HINCKLEY NATIONAL RAIL FREIGHT INTERCHANGE

Project reference TR050007

Applicant's response to Deadline 6 Submissions [part 2 - HBBC]

Hinckley & Bosworth Borough Council

Written Statement of Oral Case ISH6 [Appendix C – Plan for A47 link road footway/cycleway design]

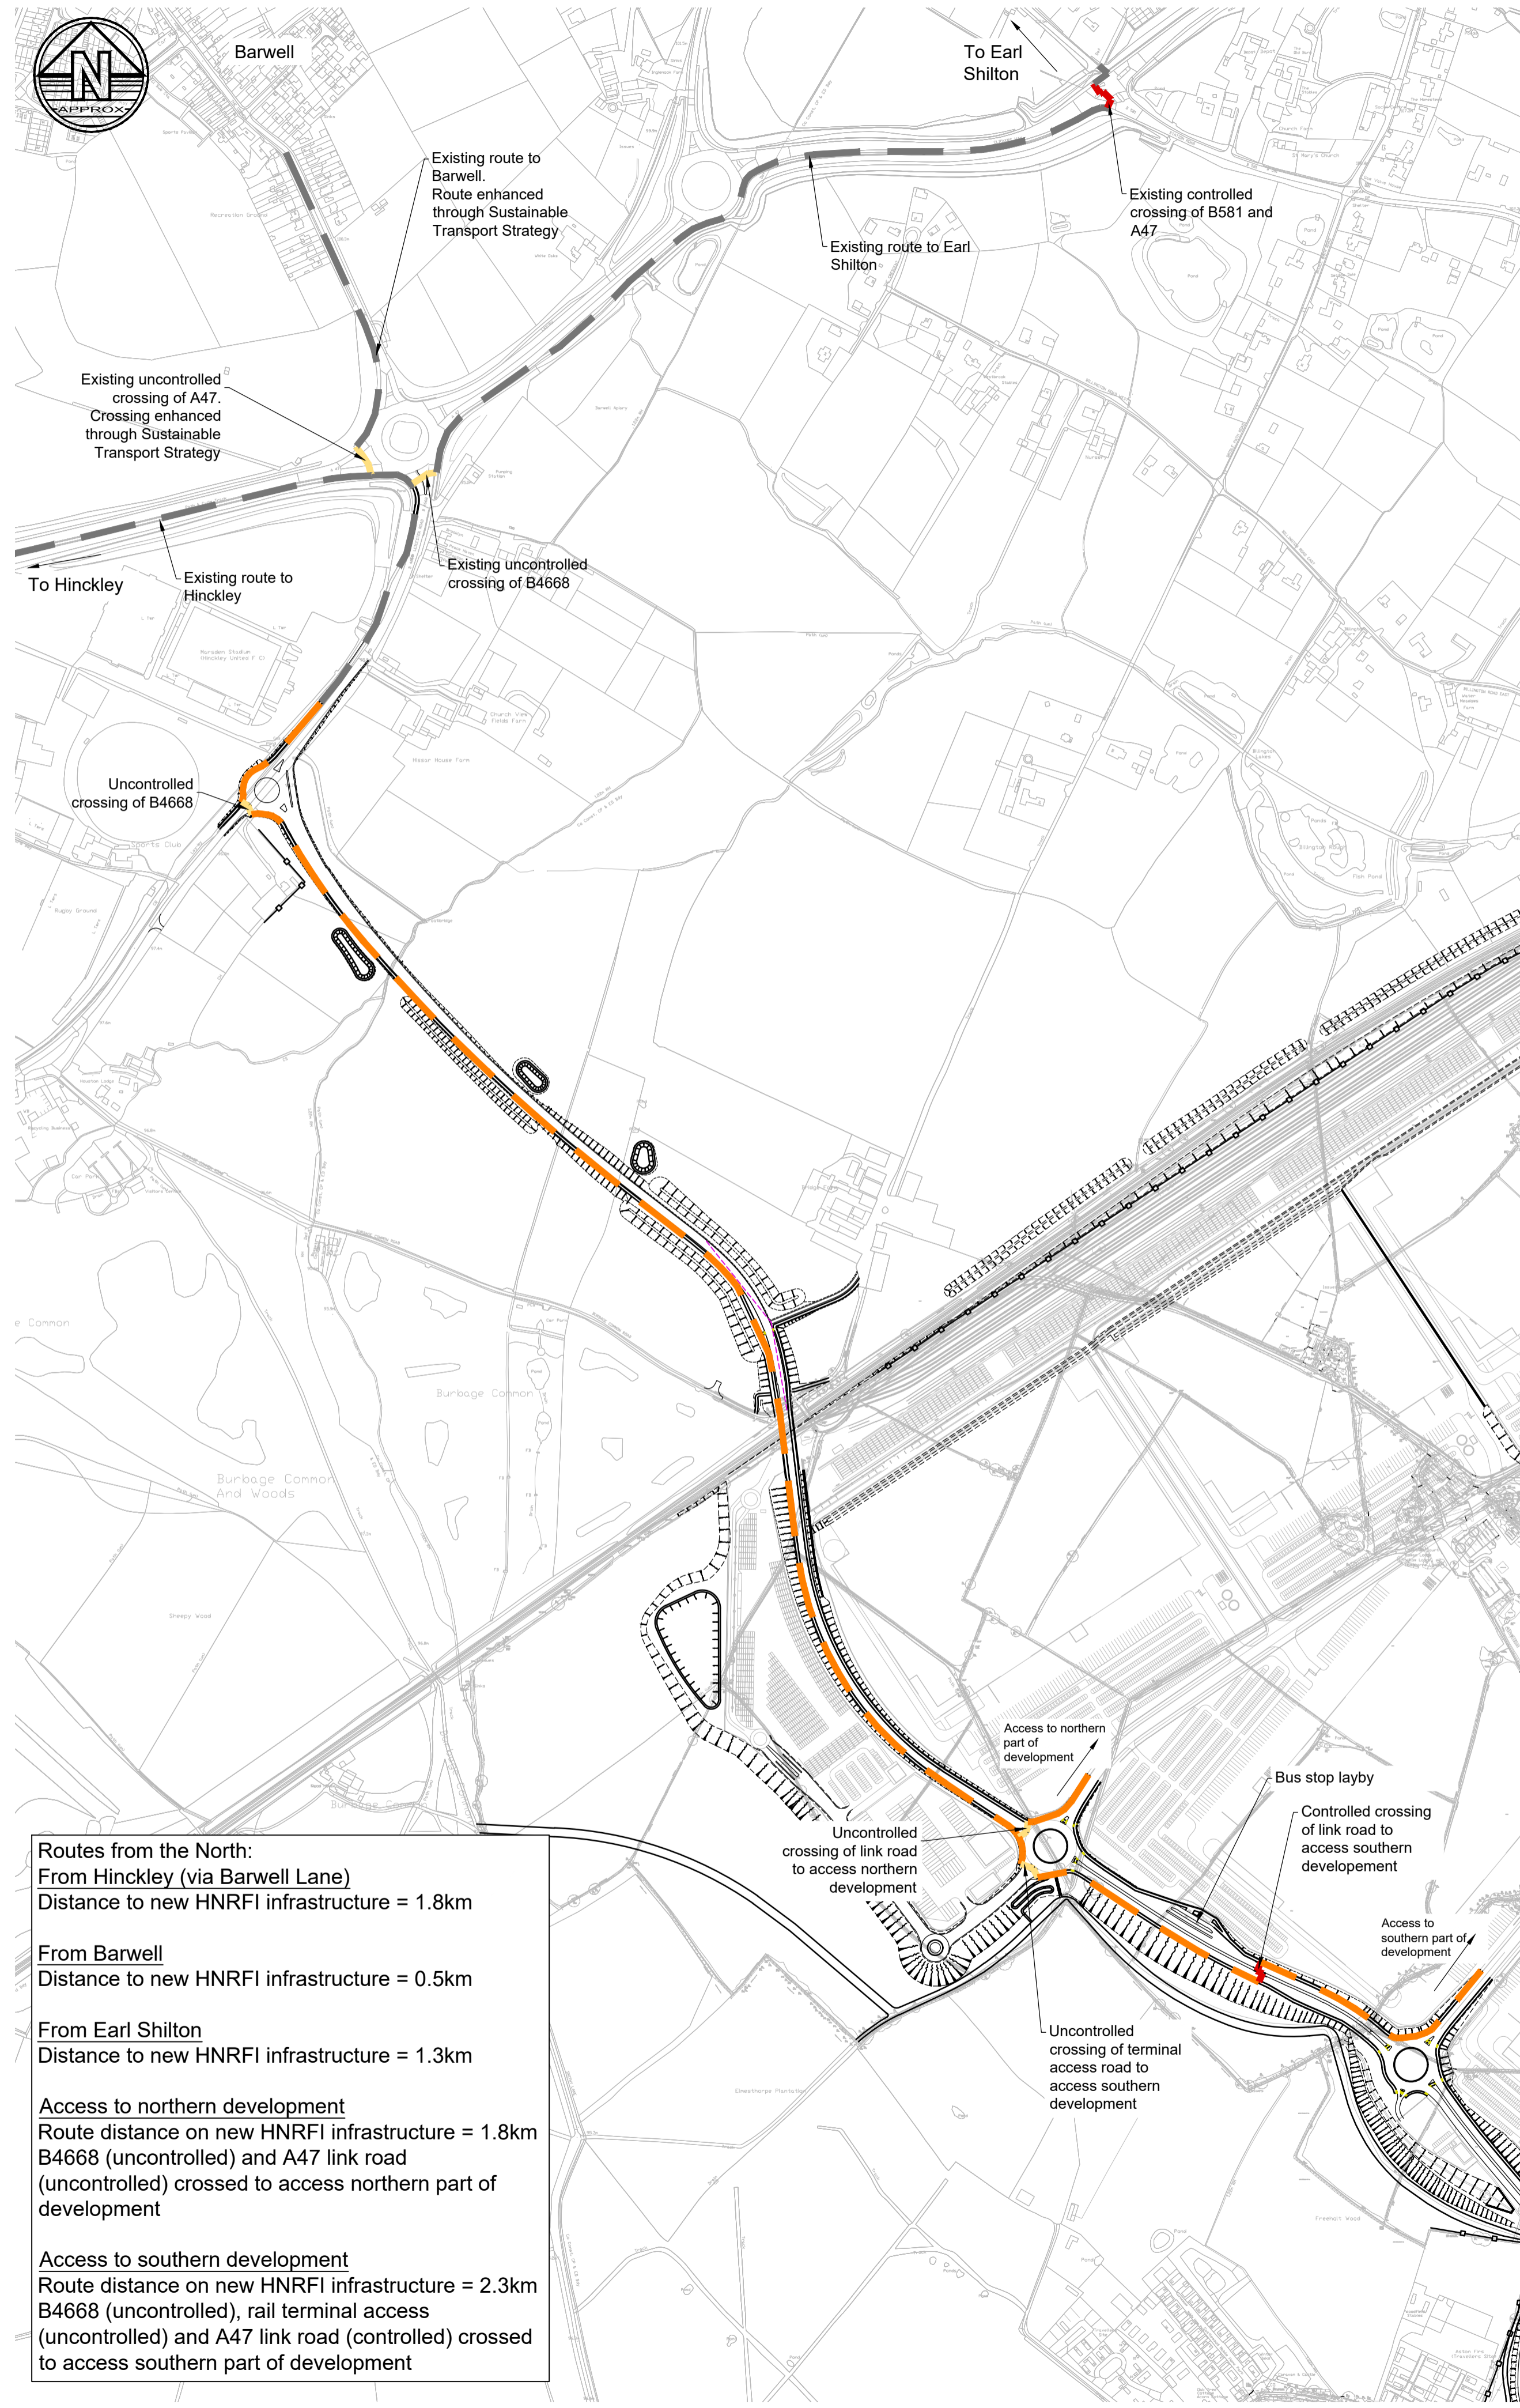
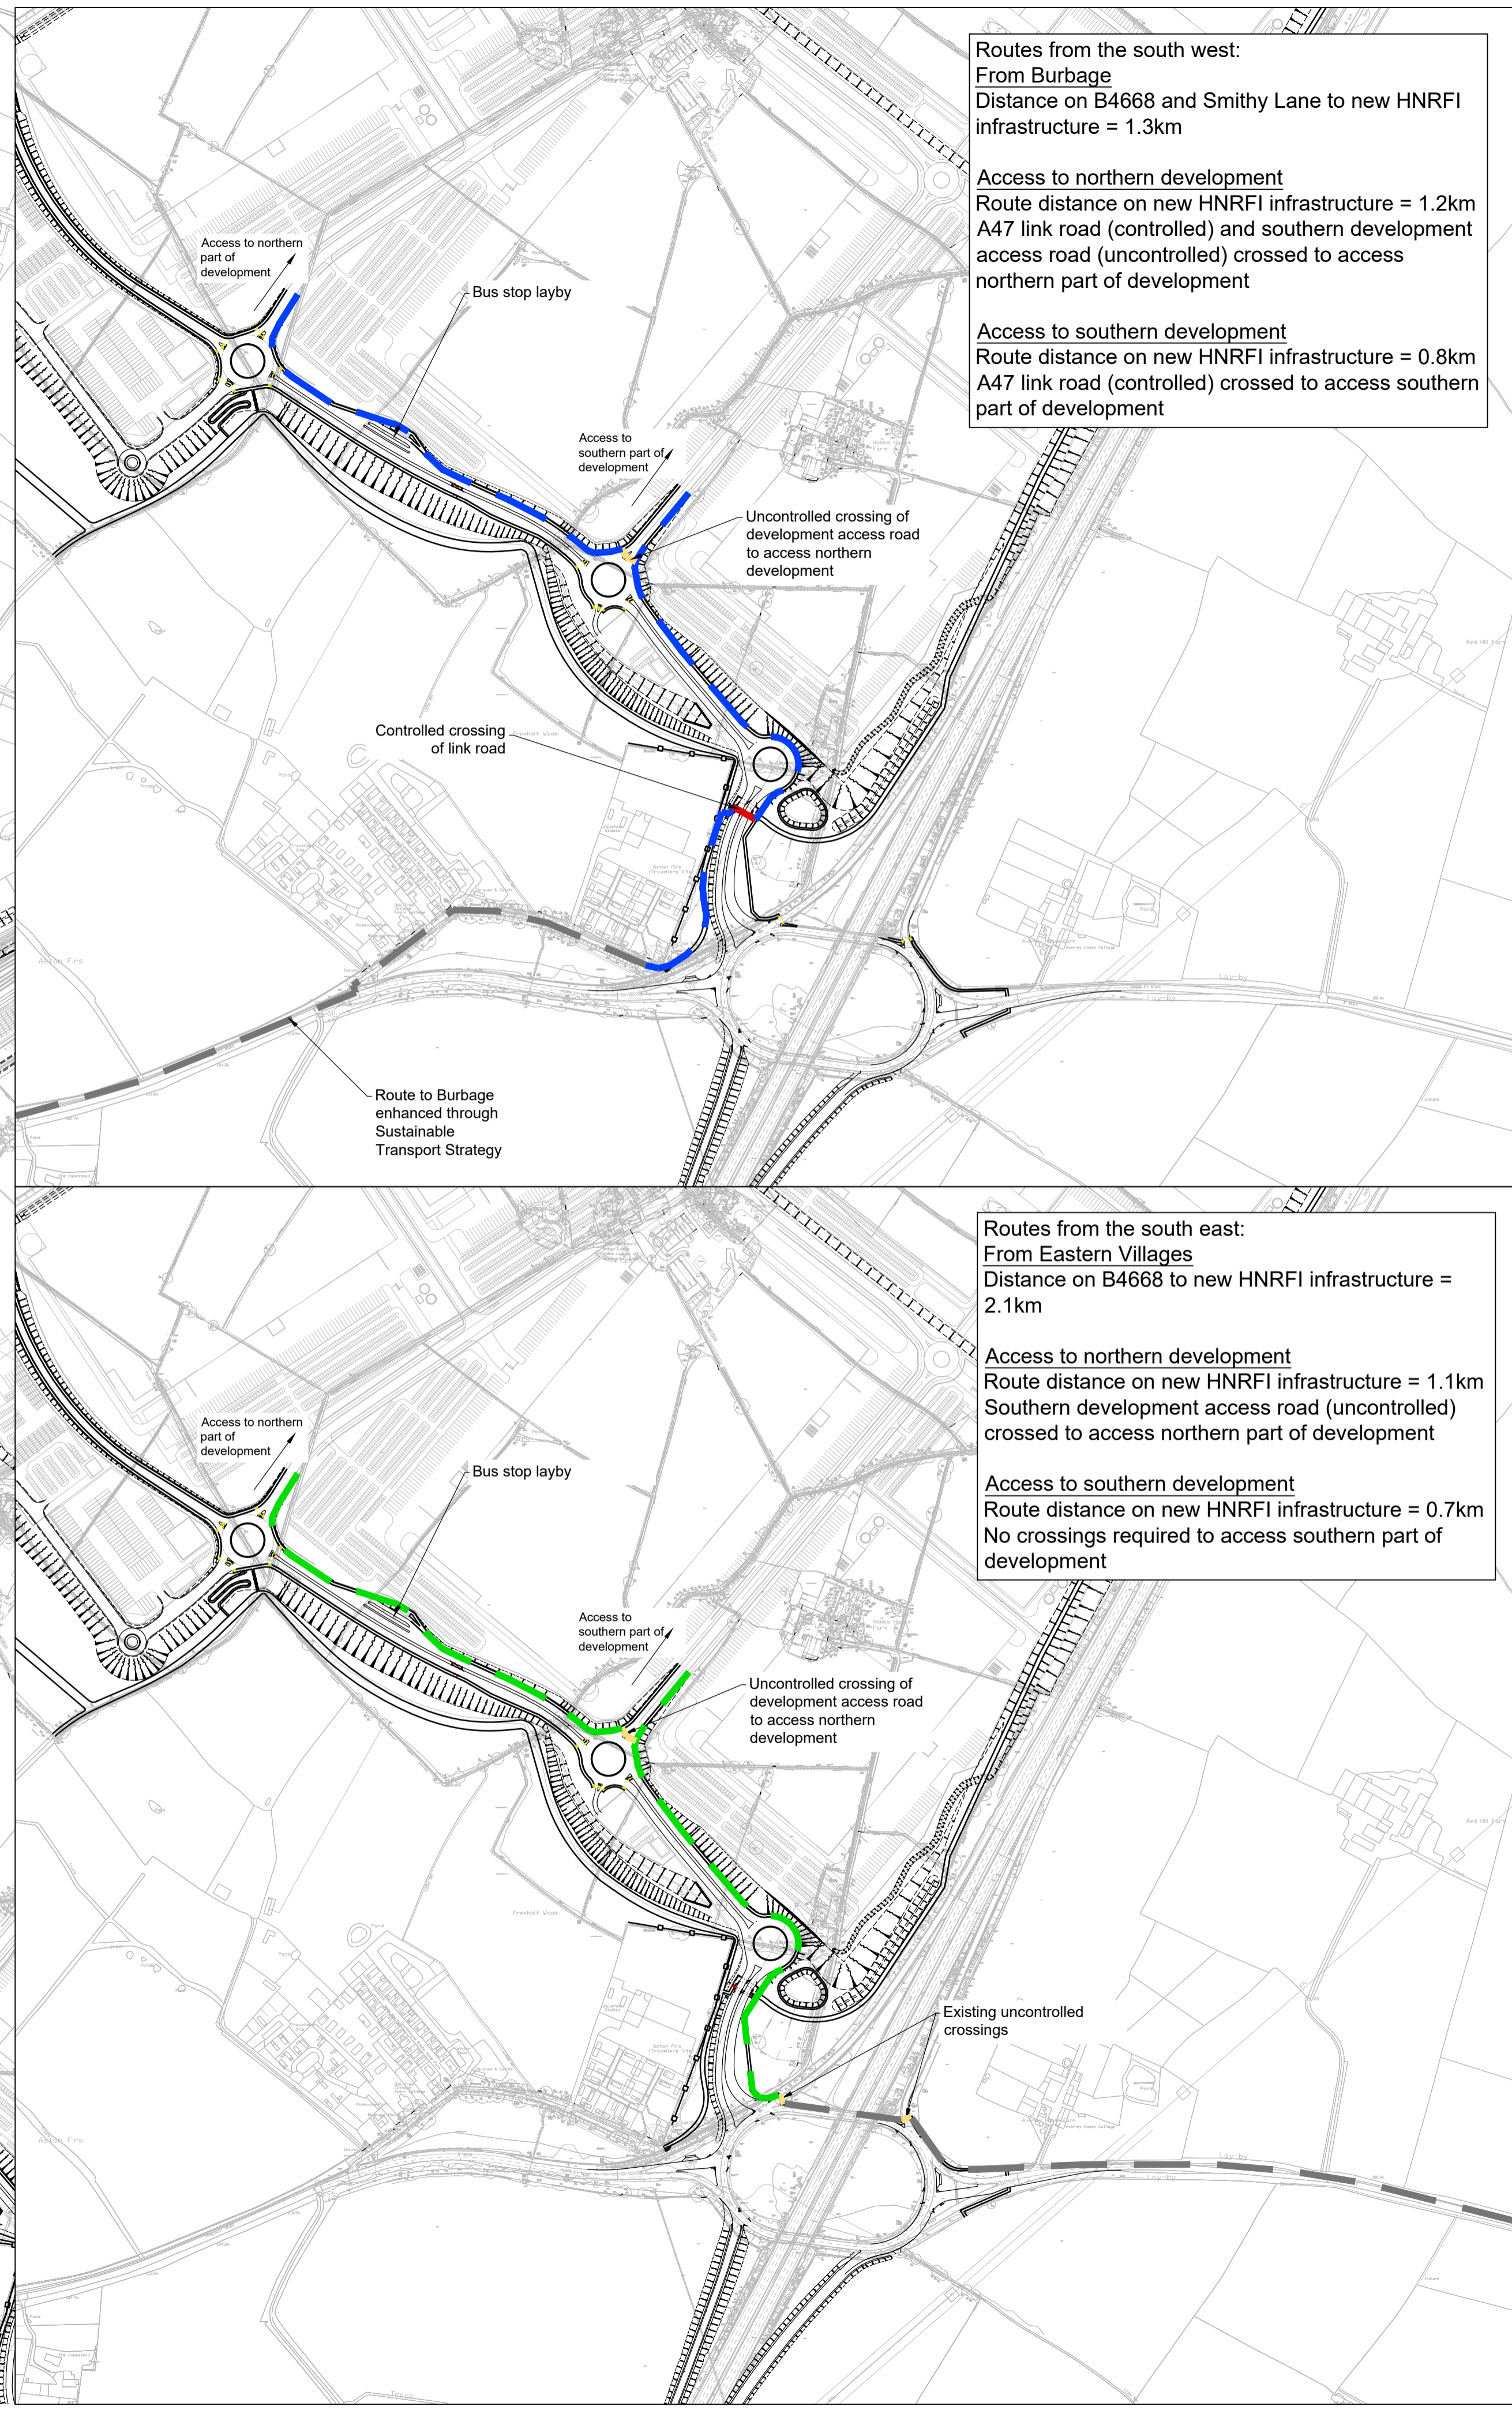
10. A47 footway/cycleway There is a reference to 'further connections will be included as Estate road' – the Council requests that this be clarified; will this mean cyclists using the estate roads with other traffic or some form of shared/segregated safe facility	Estate roads will have footway/cycleways separate from the main carriageway. This is clear from the plans submitted with the Geometric Design Strategy Record (document reference: 2.29B, REP5-004)
	<p>10-13 proposed cycle enhancements – HBBC have already commented at Deadline 5 on the shortcomings of these proposals and recommended requirements. These facilities should be provided before first occupation as stated at Deadline 5.</p> <p>Missing commitments</p> <p>There is no commitment to a shuttle bus between the bus stops and site as indicated in previous documents; this should be added and specified in terms of frequency, route, capacity etc.</p> <p>There should be a commitment to provision, monitoring and management of car parking to accord with the objectives and outcomes required from the Sustainable Travel Strategy and Framework Travel Plan.</p> <p>A further commitment should be provided on the Travel Plan Steering Group, making it clear the composition, protocol and frequency of meetings, role and decision-making etc. – the Council has set out in the comments on the Framework Travel Plan recommendations on these issues, and the STS should be amended to refer to this.</p> <p>Another major point is that there is no commitment to the targets for the plans and what will be done should these targets not be achieved ; the applicant referred to funding being set aside for further measures at Deadline 5, but this now no longer seems to be referred to. It is the Council's view that (1) a commitment to targets should be included (2) these targets should be appropriate, as noted in other Council comments and (3) there should be funding set aside or able to be provided from the applicant should the plans not be achieving the targets.</p>	<p>Noted and commented upon in Deadline 5 Review (document reference: 18.19)</p> <p>This was rectified in the Deadline 6 (document reference: 6.2.8.1D, REP6-005) submission and is included within the updated table of commitments. A shuttle bus will be present on site during operational hours and will coincide with public bus arrivals at the interchange. The STS provides further details on how this will operate initially and once the site becomes more fully occupied.</p> <p>The Framework Site Wide Travel Plan (document reference: 6.2.8.2D) includes a car park management provision within the Measures and Incentives Paragraph 7.31.</p> <p>The requirement within the DCO for the Framework Site Wide Travel Plan secures the set up of a Travel Plan Steering Group. The Applicant's view is that the details on composition and protocol are better agreed post decision. Frequency is committed as being annual.</p> <p>The STS (document reference: 6.2.8.1E) as a document secures the commitments within it, this includes the mode shift targets within the report. The monitoring of the targets on an annual basis and mechanisms to manage them should targets be missed are embedded within the commitments in Table 1. The mentioned in reply to 1.6 the targets are appropriate and realistic. The deadline 7 update to the STS sets out the modal shift target as the first commitment of the strategy (document reference 6.2.8.1E).</p>
